PAVEMENT DESIGN REPORT

**Falcon Meadows at Bent Grass, Filing No. 3
El Paso County, Colorado**

JOB NO. 195343

PCD File No. SF Number 2216 and PCD File No. PAV247

TEST BORING
LOCATION PLAN

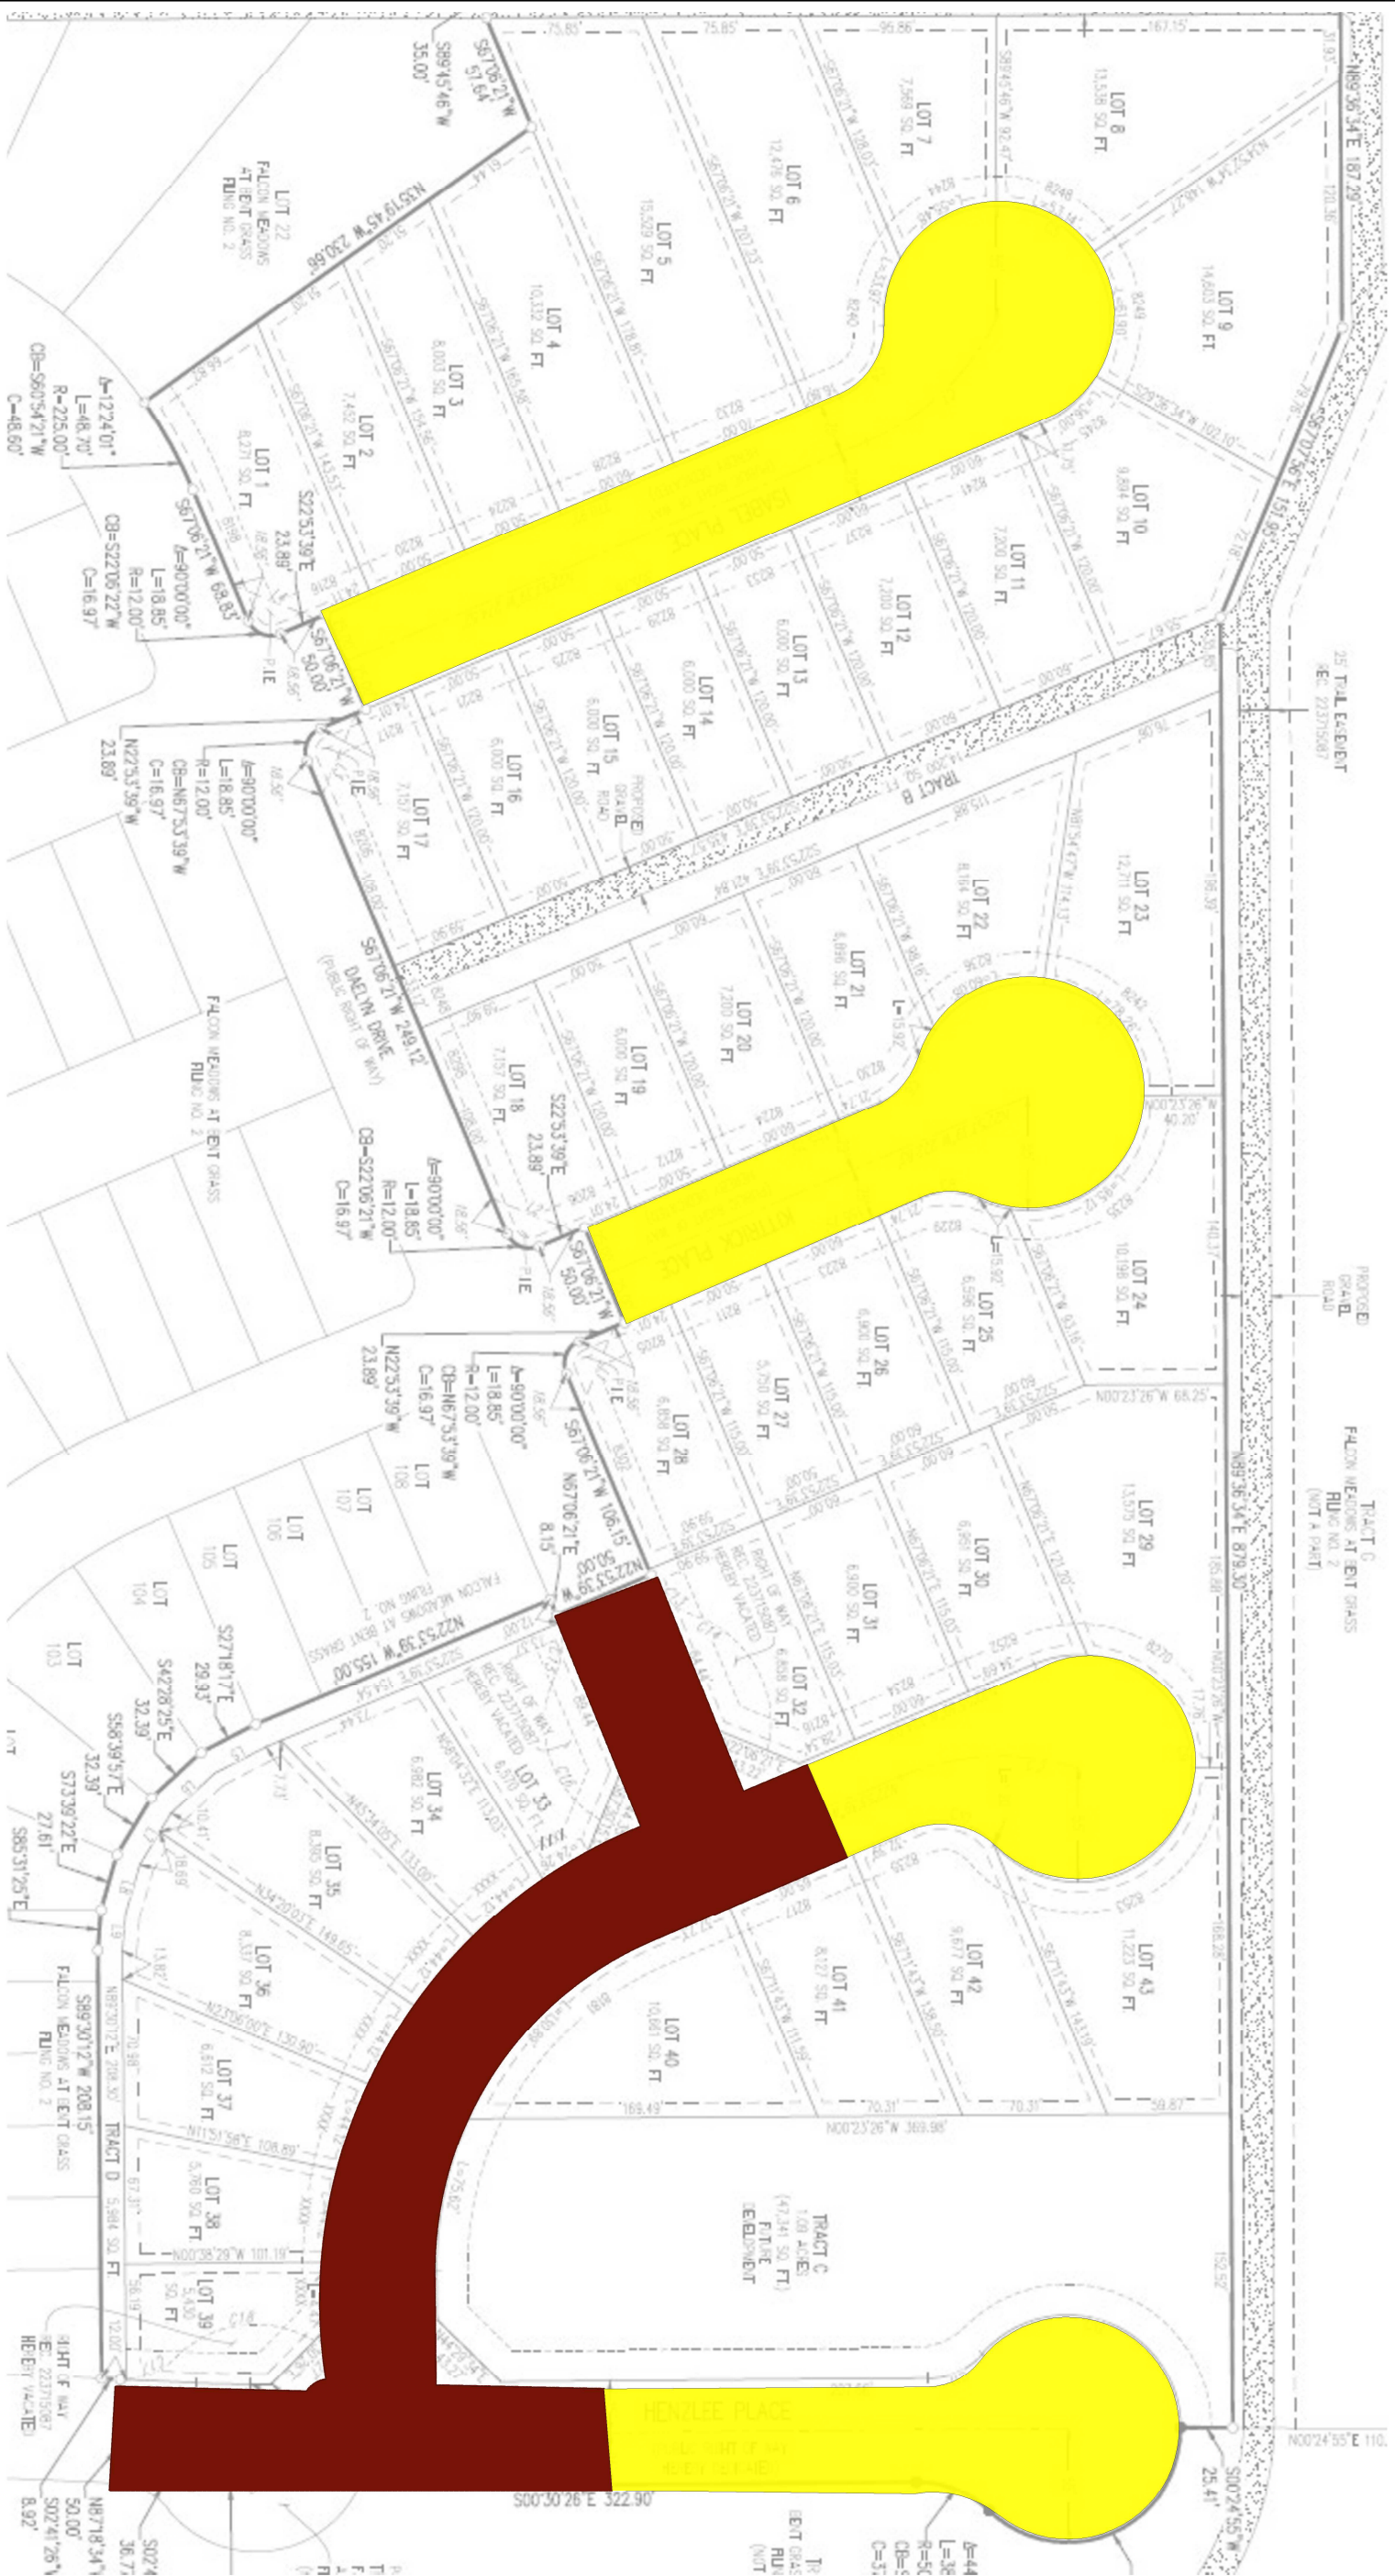
Revise to add a scale to the drawing.
